**Re: SSI 5414 MOD1  
North West Rail Link  
Windsor Road Bridge, Rouse Hill Modification Report**

The submission has been prepared in relation to the proposed modification of the Stage 2 State Significant Infrastructure approval (Ref. SSI-5414) granted by the Minister for Planning and Infrastructure under Part 5.1 of the Environmental Planning and Assessment Act, 1979, on 8 May 2013. The proposed modification relates to the crossing of Windsor Road, at Rouse Hill ("Skybridge").

This submission is made by The GPT Group (GPT), owners and managers of Rouse Hill Town Centre - a mixed use Major Centre under the prevailing metropolitan, sub-regional and local government strategic planning hierarchies.

Figure 4 - Indicative layout
12

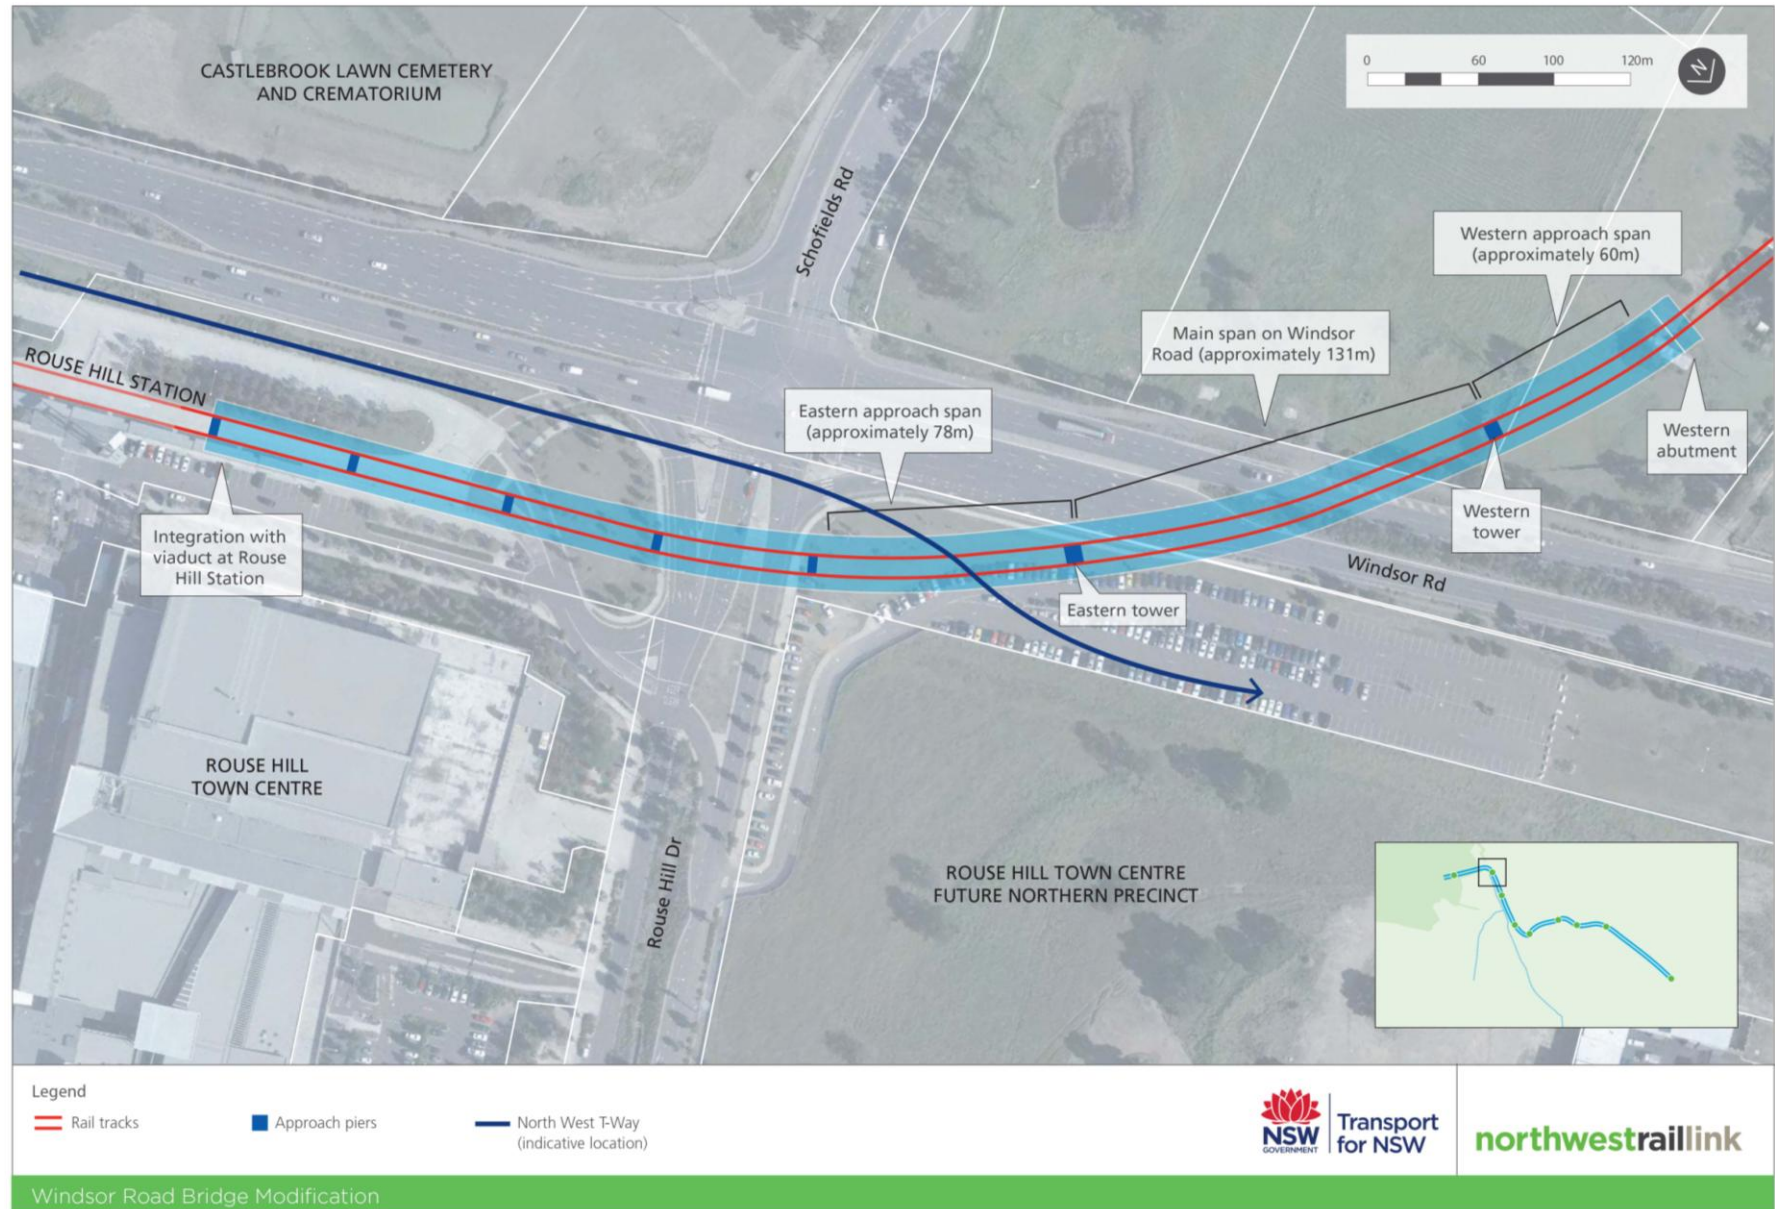
- Figure 4 – the new design of the Skybridge with the revised pier location should be overlaid on top on the latest intersection design of Windsor Road / Rouse Hill Drive / Schofields Road to confirm if the piers would be in conflict with the intersection layout and any future changes / expansion of the intersection approaches on Rouse Hill Drive and Windsor Road. The benefits of the reduced impacts on the design of Windsor Road approach should be clearly shown and documented;

- Figure 4 – the new design of the Skybridge with the revised pier location should be overlaid on top on the latest T-way extension and northern bus layover to confirm if the piers would be in conflict with any of these elements

- Figure 4 – the new design of the Skybridge suggests buses north of Rouse Hill Drive will move closer to orchard Rd, this should be overlaid on top of the latest T-way extension and northern bus layover to confirm it works with the work done to date

- RMS have previously identified that a grade separation of Windsor and Schofields Rds is to occur at some future time. Do the new pier locations for the Skybridge contemplate this future grade separation?
